Letter No. **32/24272/89**

Dated: **26.6.'90.**

Sub: **MMDA - Planning Permission - construction of Ground Floor+ 2 floors residential building in two blocks at S.No. 204/20 & 28, No.5, South Madia Street, Thiruvanniyur, Madras - Development Charge, Security Deposit and Scrutiny Charge - remittance - Requested - Reg.**

CAPACITY OF O.H.W.T.
 TANK 9.03 M³ IN EACH
 BLOCK. TOTAL IN TWO BLOCKS 18.06 M³

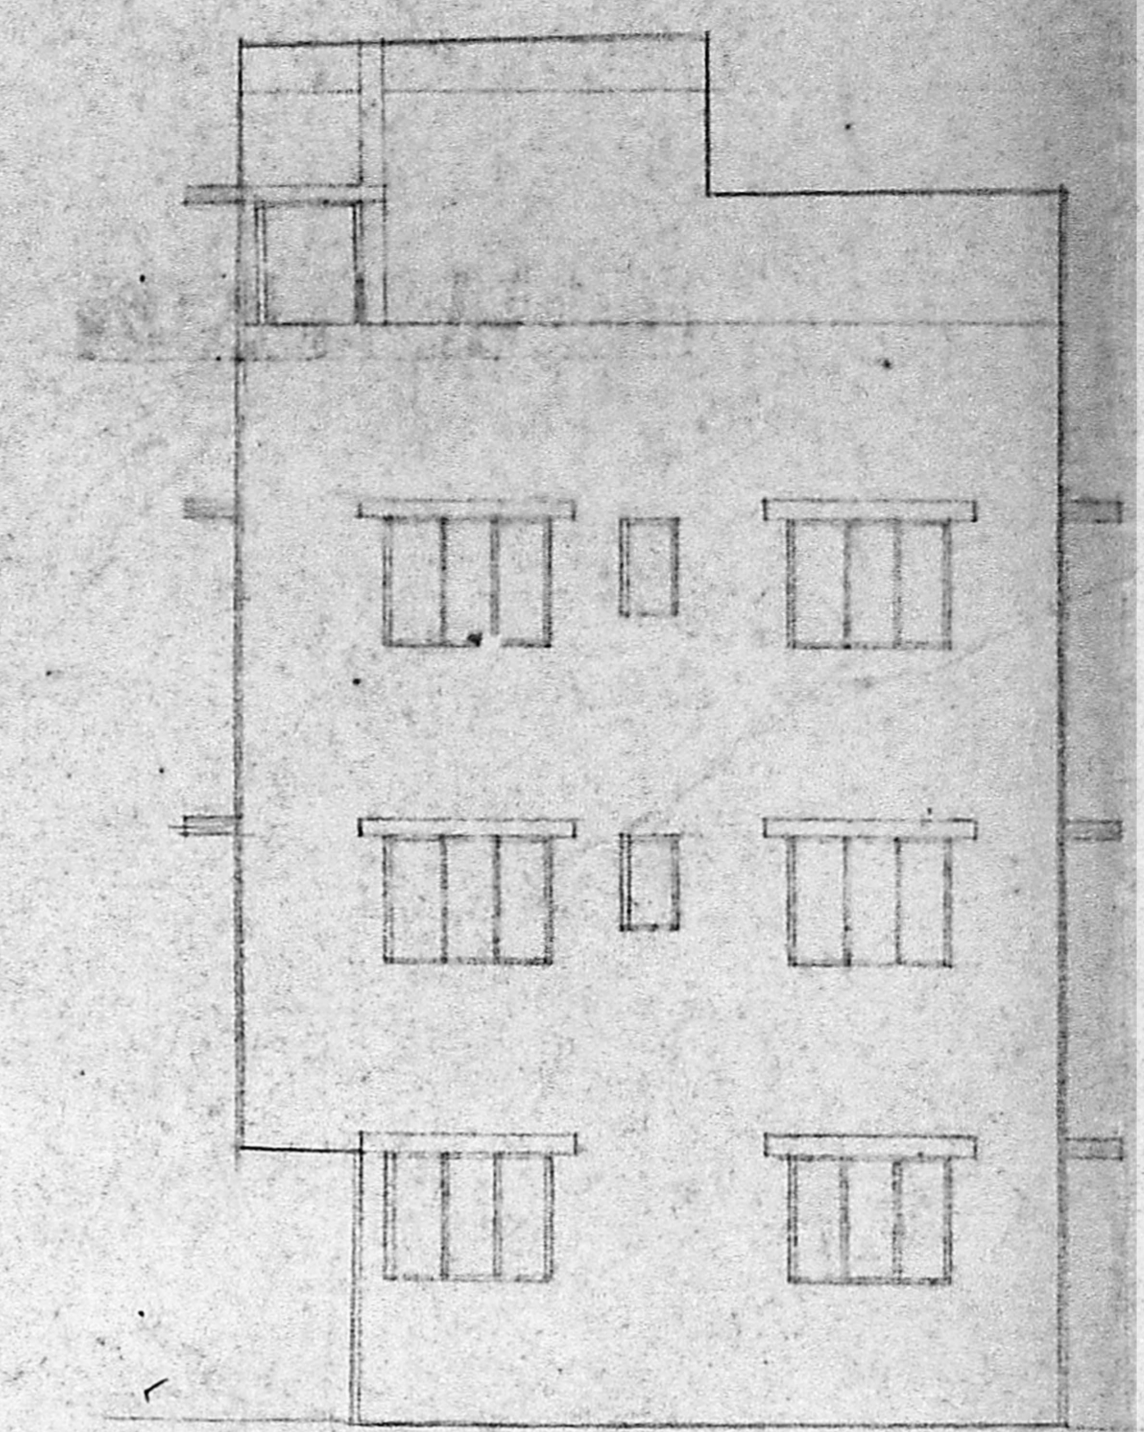
- f) **Furnish 5 Nos. the revised plan with Over Head Tank capacity of 18M³.**
